Tween Bridge Solar Farm

9.13 Statement of Common Ground with South Yorkshire Fire & Rescue Service

Document Reference: 9.13

Revision 2~~1~~

Drawing Ref: Typical 100MW BESS Layout

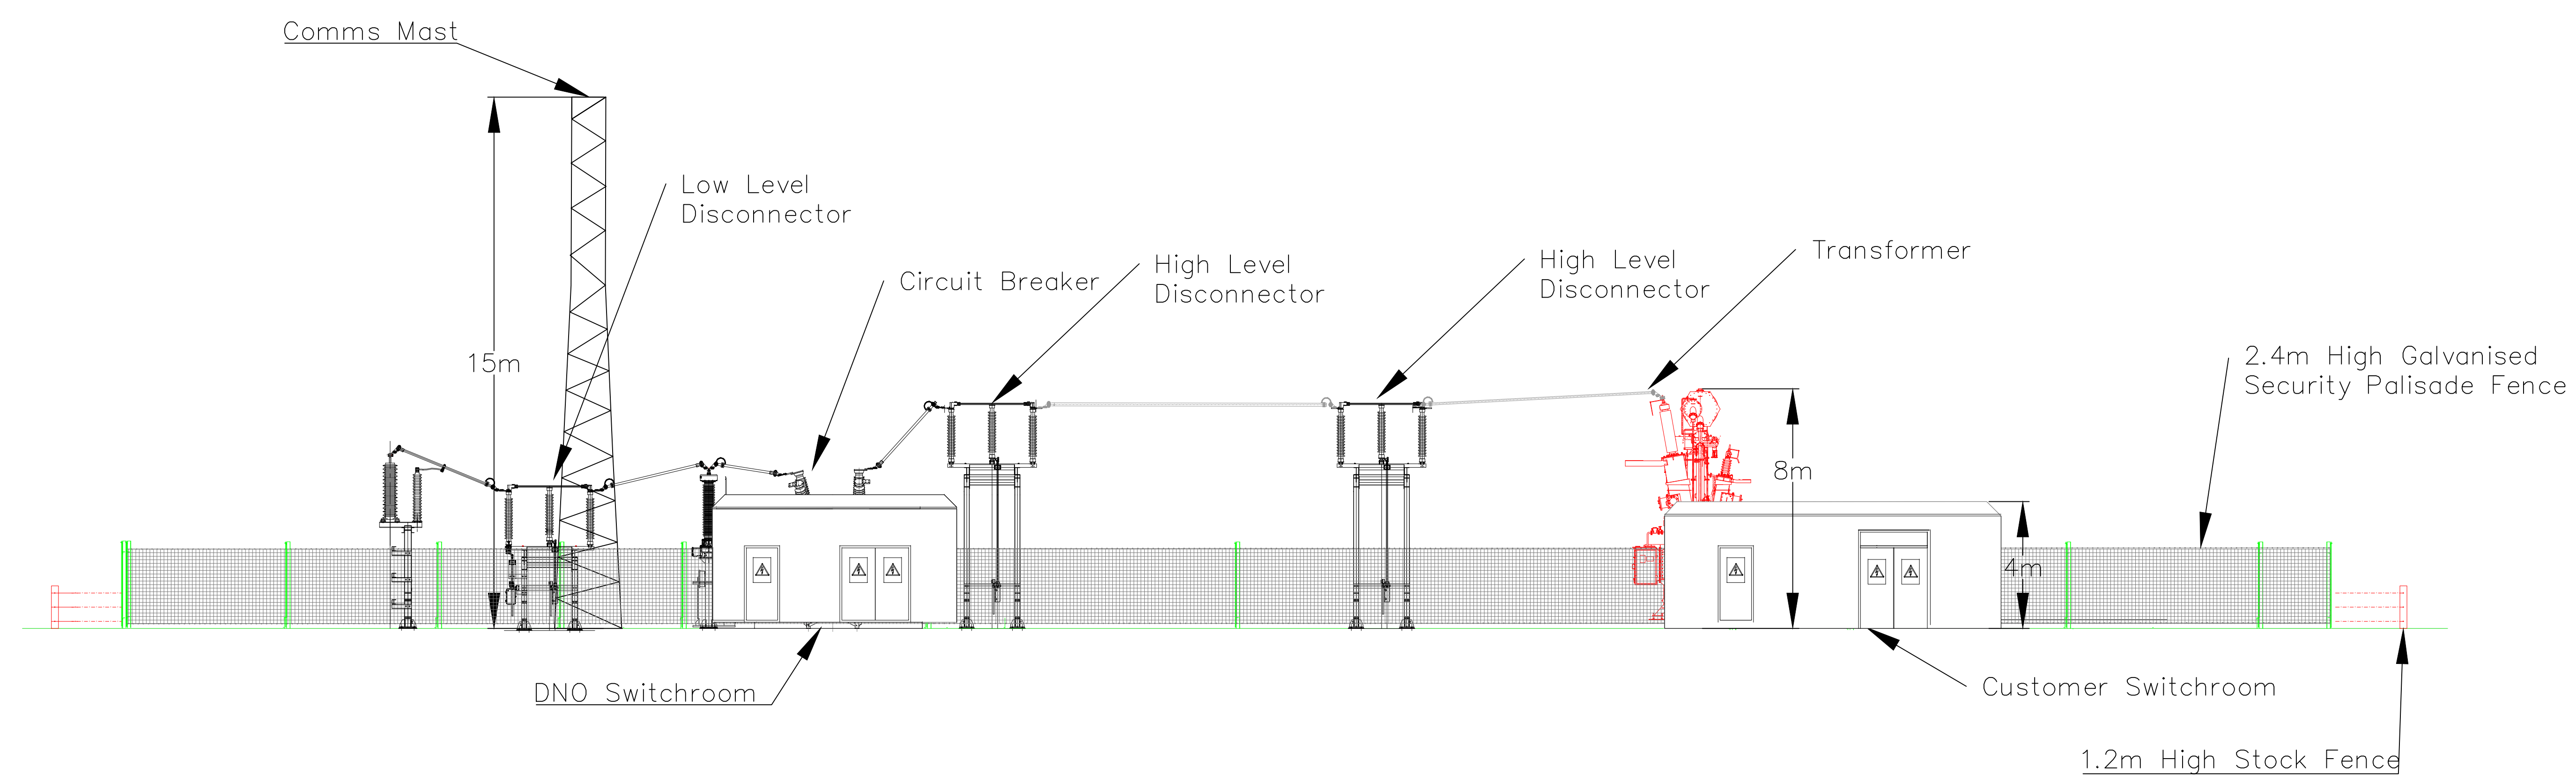
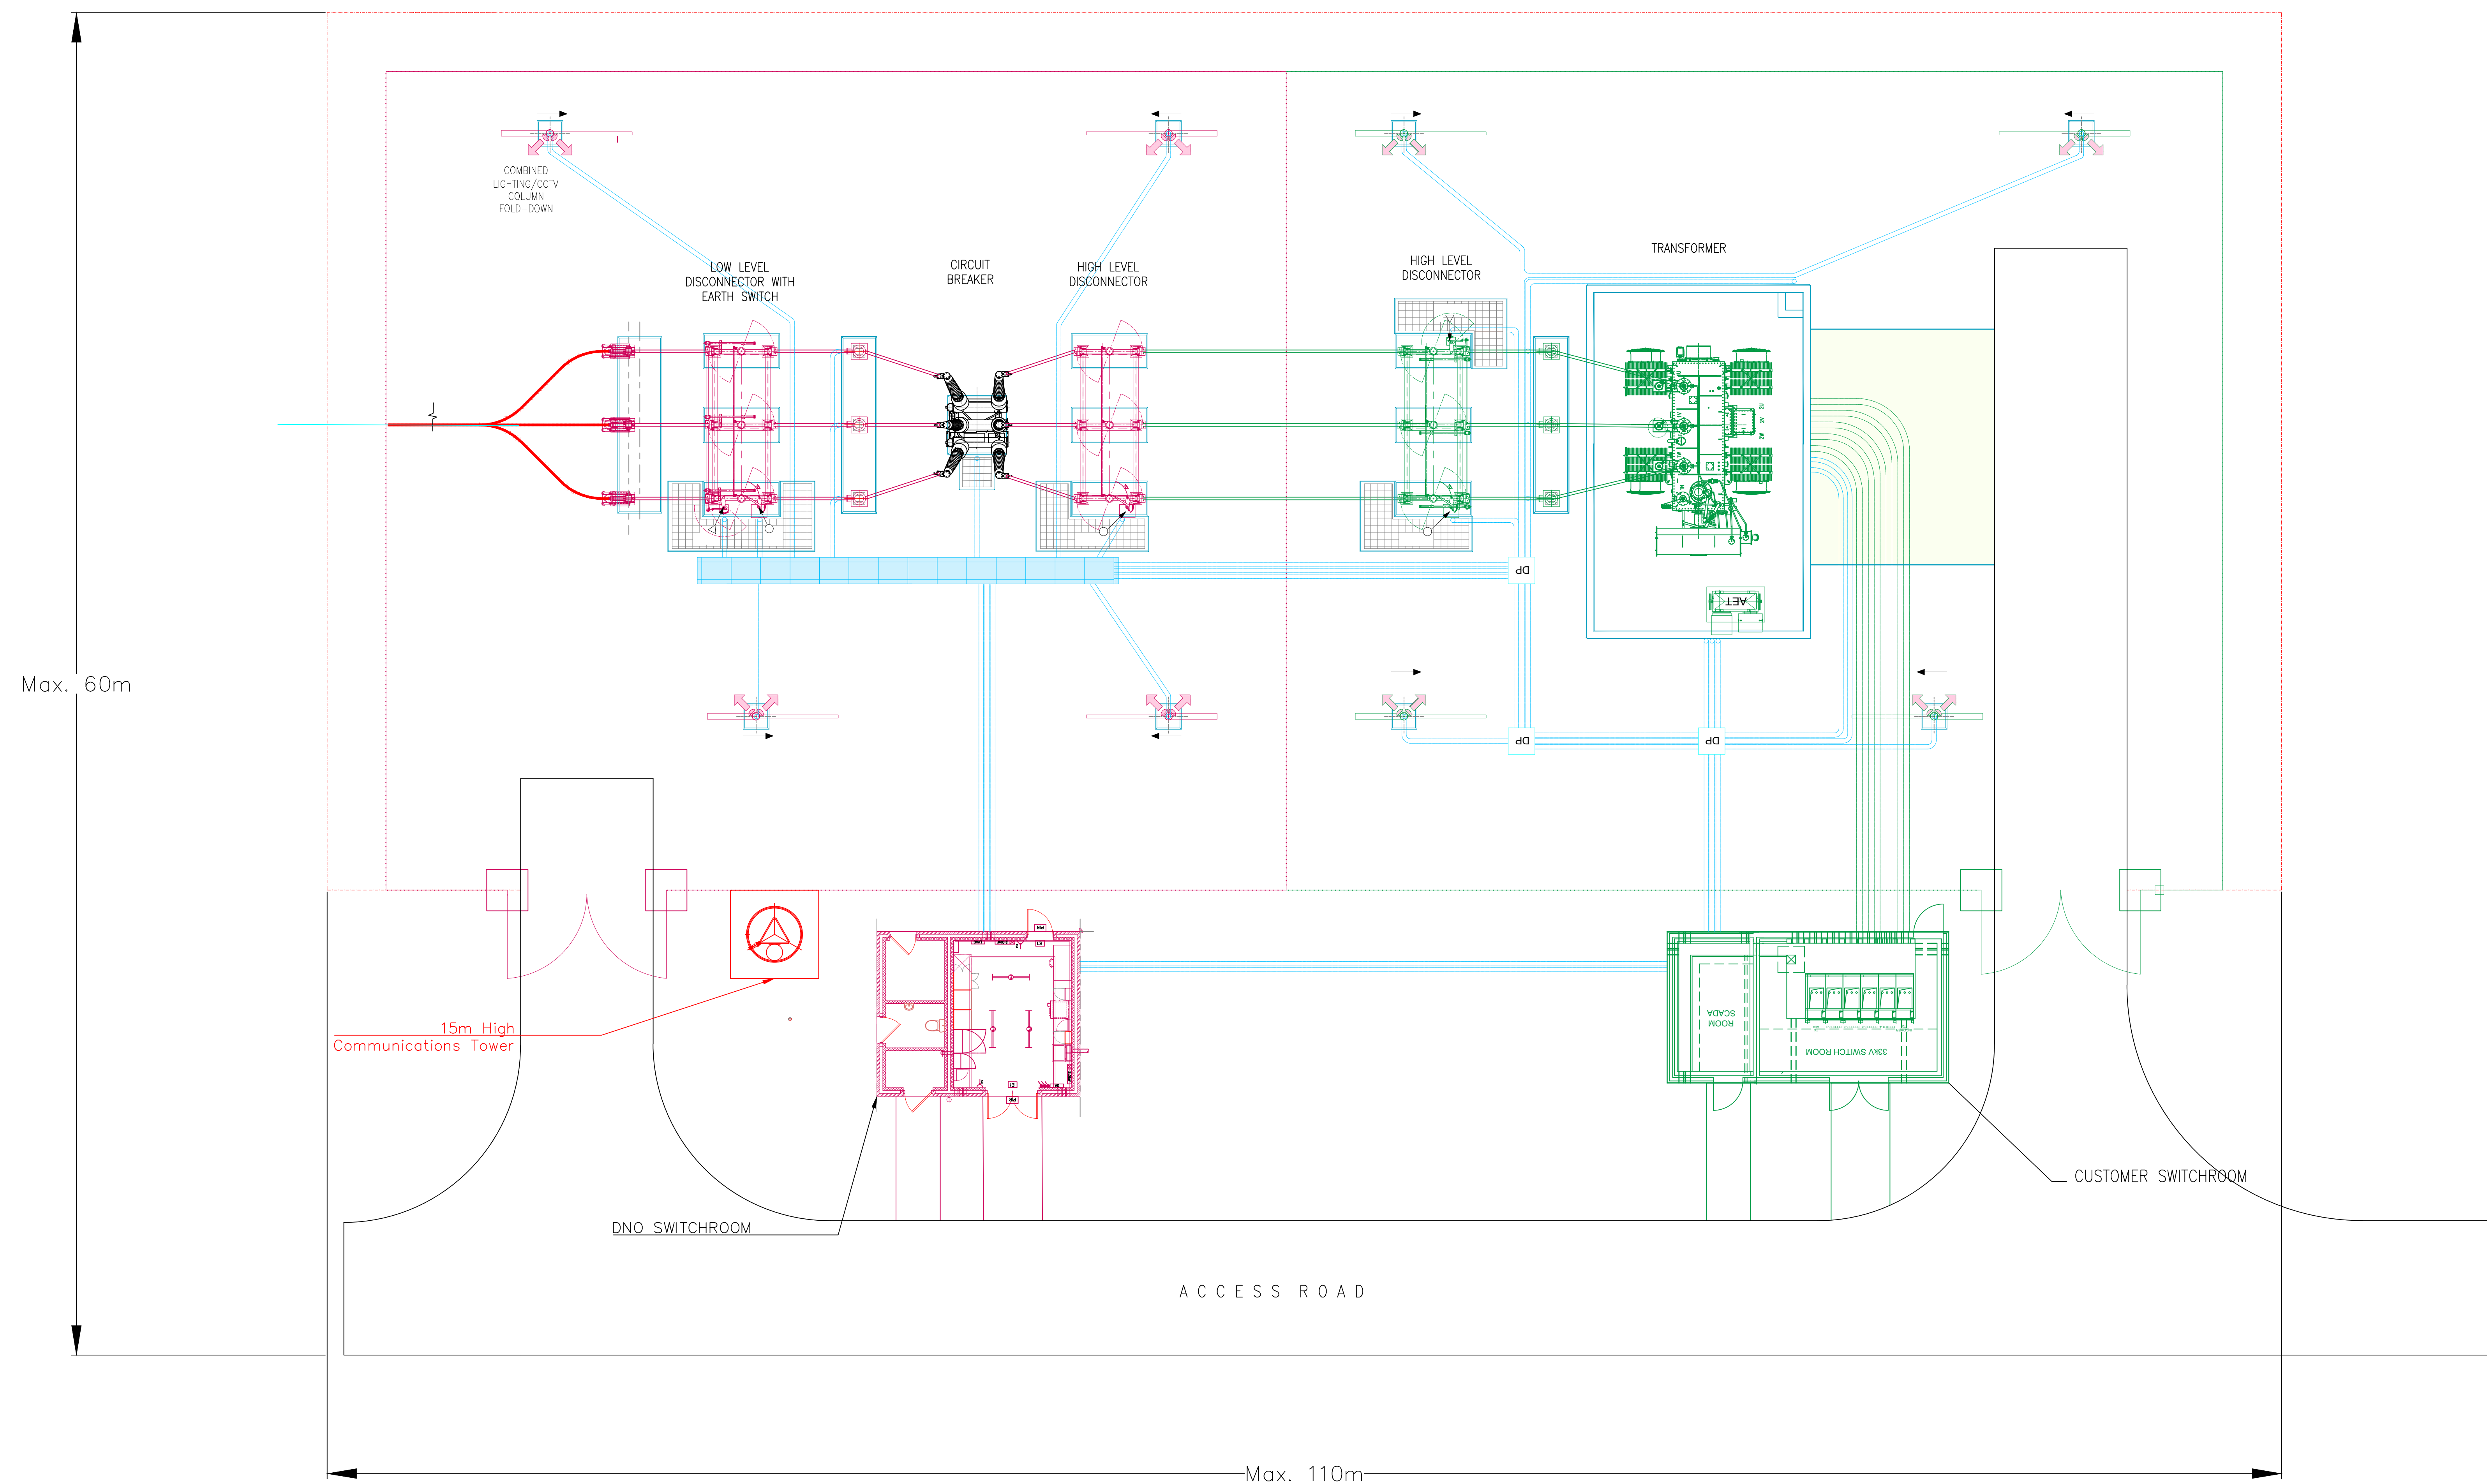
Scania Rescue Pumps and Scania Turntable Ladders		
SYFR 5	Water Supply	<p>In the event of a fire involving BESS, it is likely that SYFR will need to apply a higher than average volume of water to restrict fire spread. Please ensure that there is an adequate water supply within 90m to allow continuous firefighting operations to take place; please also ensure due consideration has been given to containing fire water run-off.</p>	<p>The Applicant confirms the BESS will be located within appropriate distance to adequate water supply. This is shown on the Illustrative Layout and Cross Section Plan [Document Reference 2.9 Revision 2APP-015].</p>	Agreed
SYFR 6	Water Supply	<p>Separators, under the site can be introduced, to contain fire water run-off. Firefighting run-off water can have a serious impact on the environment and nearby open water. Having water separators under the site to contain this hazard means the water can be properly disposed of after the incident.</p>	<p>The outline surface water drainage strategy included in the Flood Risk Assessment [APP-108REP2-047, REP2-049, and REP2-051] has been designed to manage potentially contaminated fire water and ensure it does not pollute the local water environment. Any fire water will be</p>	Agreed

contained below ground prior to testing and subsequent release or disposal, as appropriate.	
SYFR 7	Spacing between BESS units	<p>In order to restrict fire spread it is essential that suitable space be maintained around the BESS. If this space is not provided this may allow rapid fire to spread to nearby structures and combustible items.</p> <p>The emergency response plan should be predicated on the scenario of the fire will not spread beyond the BESS container of origin. With fire and rescue operations limited to boundary cooling of surrounding BESS and monitoring the BESS involved in thermal event.</p> <p>This outcome can be achieved through a number of different routes including:</p> <p>3.1.4. Adequate separation between the BESS enclosures to ensure that the radiant heat from a thermal event in one BESS will not trigger a secondary event.</p> <p>3.1.5. Provision of fire resistant materials that will prevent direct flame impingement or radiated heat affecting adjacent BESS and</p>	<p>The Applicant has provided an indicative layout for a 100MW BESS within the Indicative Layout and Cross Section Plans (Rev 1) [Document Reference 2.9 Revision 2 APP-015]. The Applicant has provided an indicative layout for a 100MW BESS within submission document Indicative Layout and Cross Section Plans (Rev 1) [Document Reference 2.9 Revision 2 APP-015], which confirms the BESS layout within the Scheme can accommodate gaps between the containers in accordance with the NFCC guidance. The approval of final layouts are secured through Requirement 6 of the Draft DCO [Document 3.1 Revision 3] which will also ensure compliance with the guidance. Appendix A of the Outline Battery Safety Management Plan SMP [Document Reference 7.4 Revision 2 APP-179] responds to the Frequently Asked Questions regarding BESS developments including Thermal</p>	Under discussion Agreed

<p>allowing the incident to develop beyond BESS of origin.</p> <p>The provision of a suppression system to the BESS is unlikely to provide a compensatory feature to allow reduced spacing between BESS.</p>	<p>Runaway Propagation, the fire detection and suppression systems.</p> <p>The final details of the BESS and BSMP will be provided post consent and controlled through Requirement 7 of DCO, as detailed in the Draft Development Consent Order [Document Reference 3.1 Revision 63].</p>	
SYFR 8		<p>In the event that the developer cannot demonstrate that a thermal event / fire can be contained to the BESS of origin, then the developer should be referred to guidance such as the separation distances within NFPA 855 (current edition – 2023). NFPA 8551 states separation can be reduced to at least 3 feet or 0.914m between BESS if tests such as UL 9540A shows propagation does not occur.</p> <p>Consideration should also be given to the provision of automatic suppression systems within each container to delay fire spread to neighbouring BESS units.</p> <p>With consideration for ‘In rack’ suppression as the external system may not penetrate the racks. Design of the suppression system is</p>	<p>The Scheme is compliant with NFCC guidance as confirmed in the Outline BSMP [Document Reference 7.4 Revision 2APP-179] and the design principles are agreed.</p> <p>The final details of the BESS and BSMP will be provided post consent and controlled through Requirement 7 of DCO, as detailed in the Draft Development Consent Order [Document Reference 3.1 Revision 265].</p>	Agree
